02 February 2022

OBJECTION - HORSLEY DRIVE BUSINESS PARK – STATE SIGNIFICANT DEVELOPMENT APPLCIATION 17161650

EXHIBITION OF EIS - HORSLEY DRIVE BUSINESS PARK STAGE 2 BUILDINGS 2 & 3 - CNR COWPASTURE ROAD & TRIVET STREET, WETHERILL PARK

Drawing Title
SITE AND GROUND FLOOR PLAN
Project Number
CH HDBP
Drawing Number
DA - 03

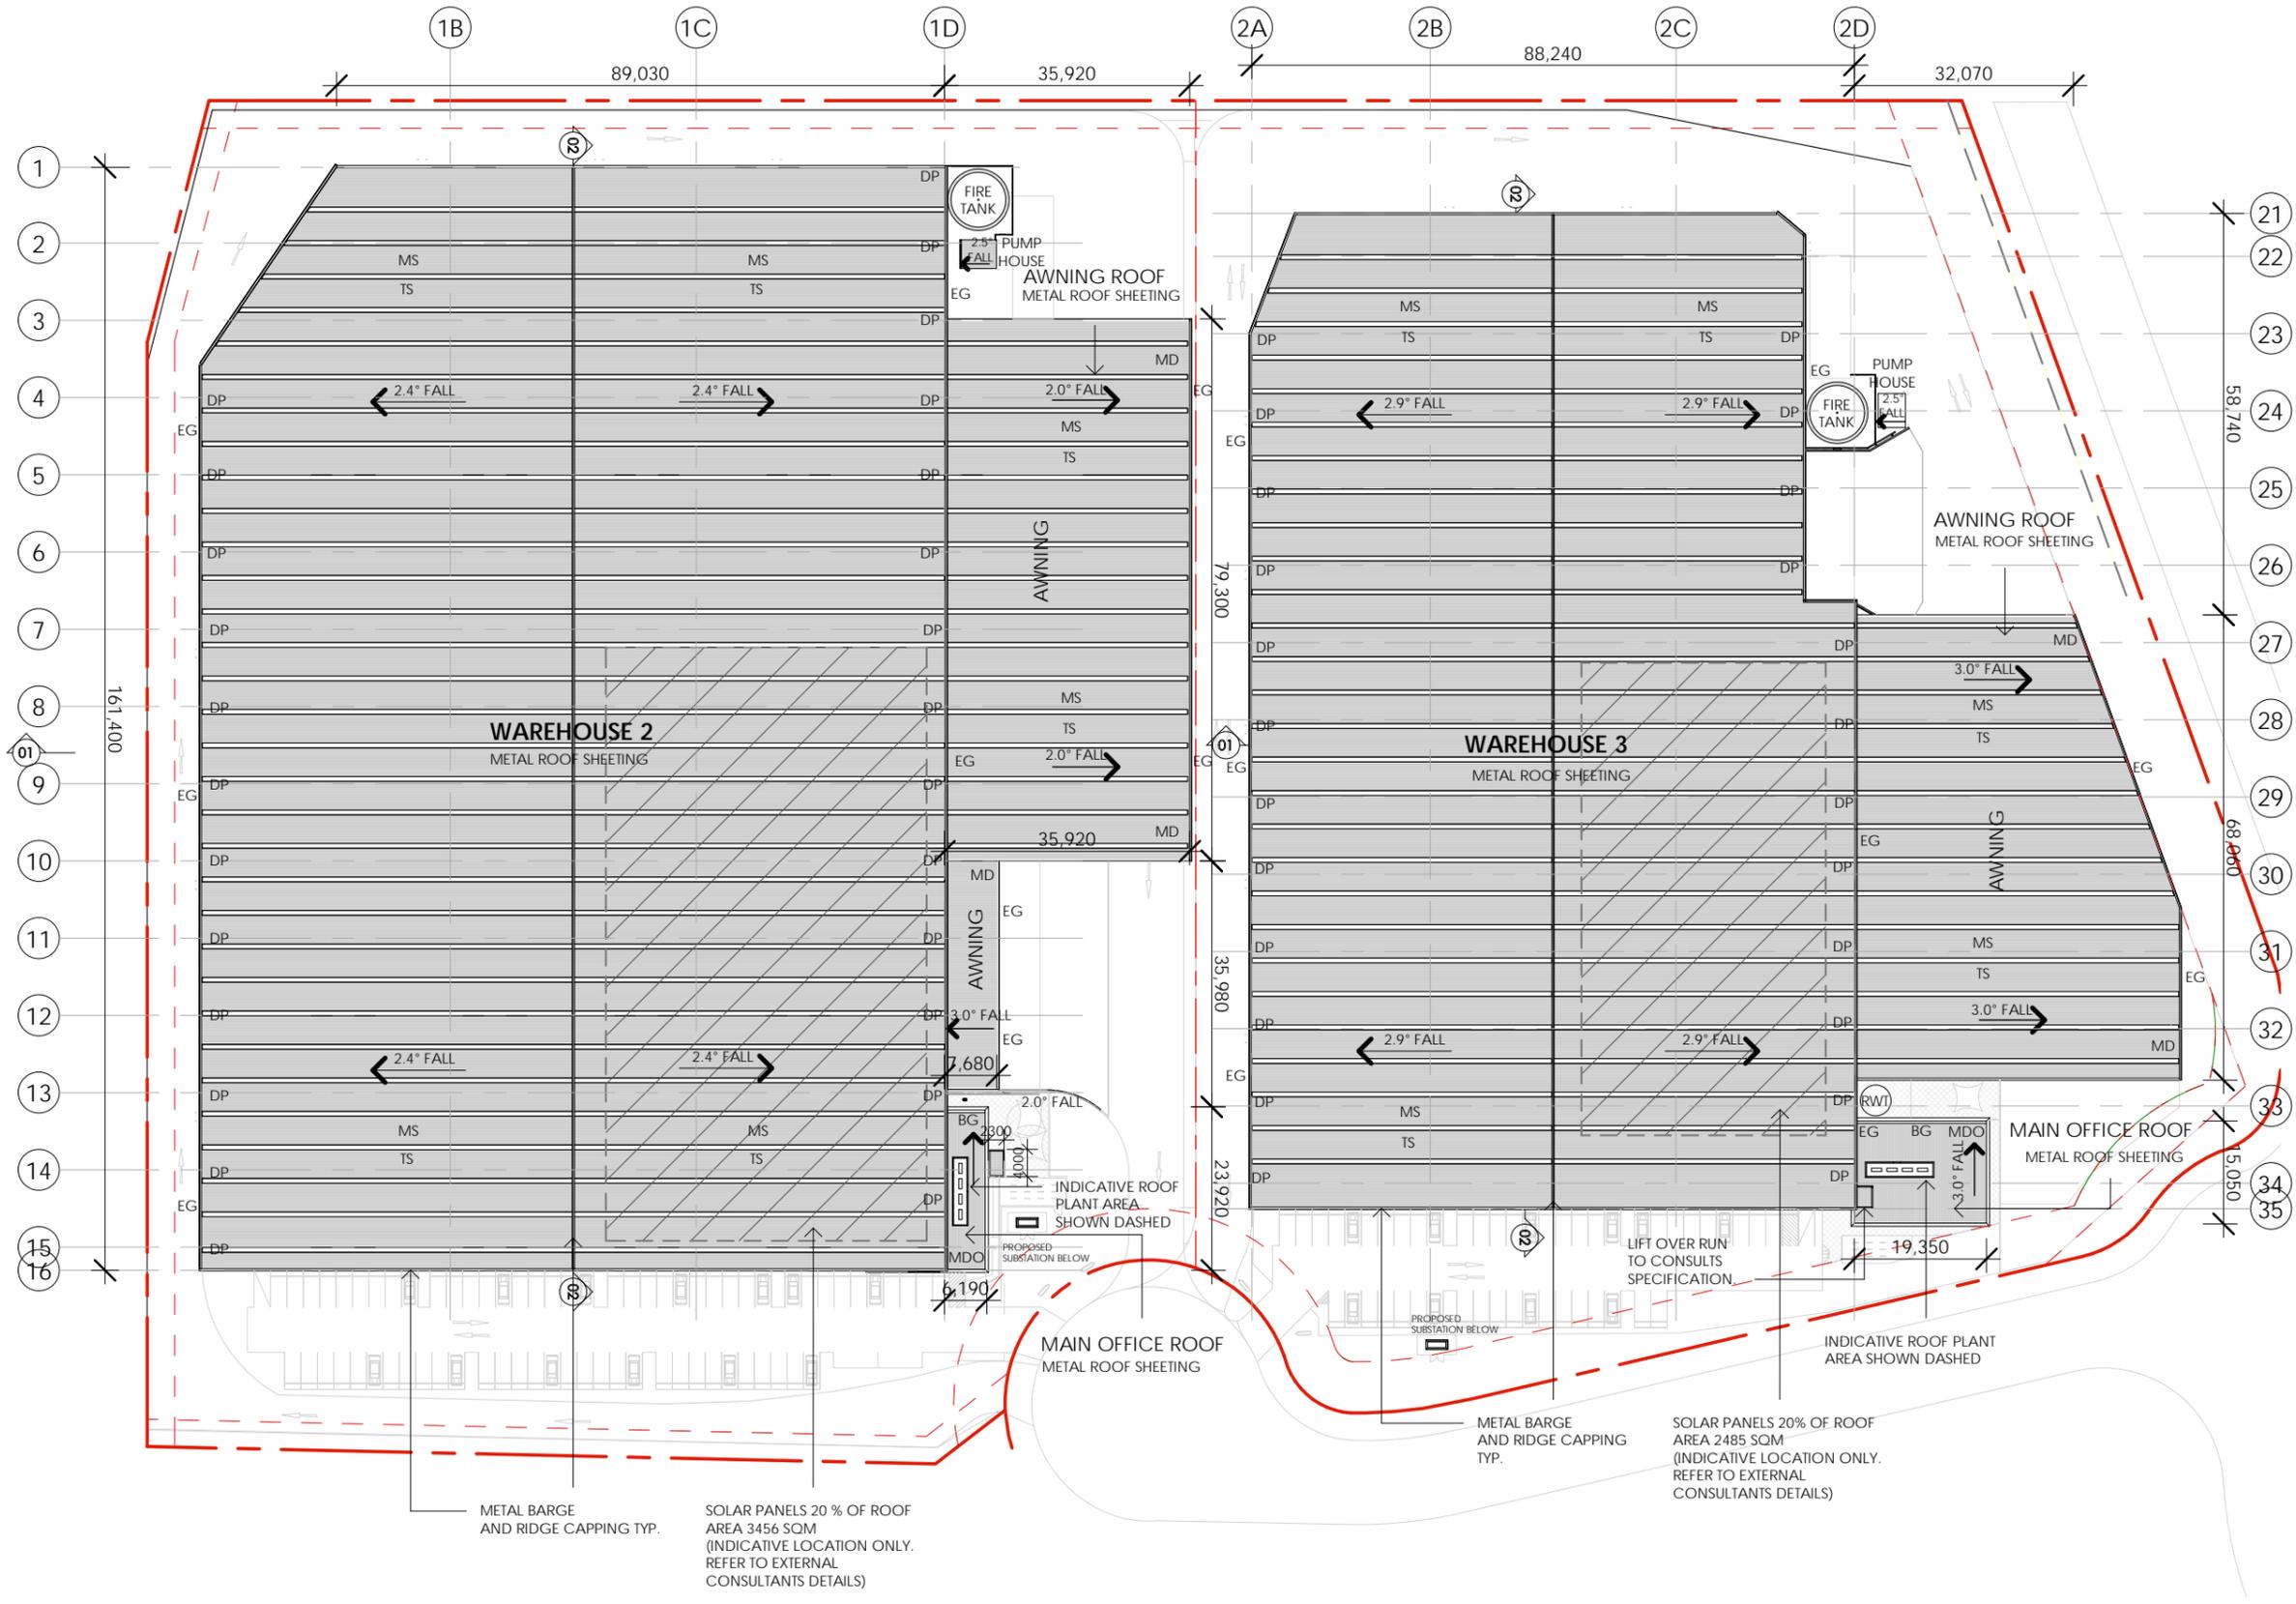
- b. Unloading/loading along the trafficable area is an issue as it will impact heavy vehicles turning into and out of the recessed loading docks or maneuvering. Consideration hasn't been given to the provision of designated loading bays to accommodate 26m B-Double vehicles to undertake loading and unloading activities. The applicant has not provided a breakdown of the number of heavy vehicles which are anticipated to use the site throughout the day. They have also not provided information on how the potential conflicts between vehicles using warehouse 2 and 3 will be managed.

- a. The truck exit point for Warehouse 2 and Combined Entry / Exit for Warehouse 3 are too close and likely to create confusion to the truck drivers servicing the sites. The access points need to be separated with adequate distance to enable safe entry and exit from the sites.
- b. The B-Double trucks shown at the loading docks at Warehouse 3 appear to encroach onto the manoeuvring areas. The truck manoeuvring areas shall be clear of loading unloading areas.
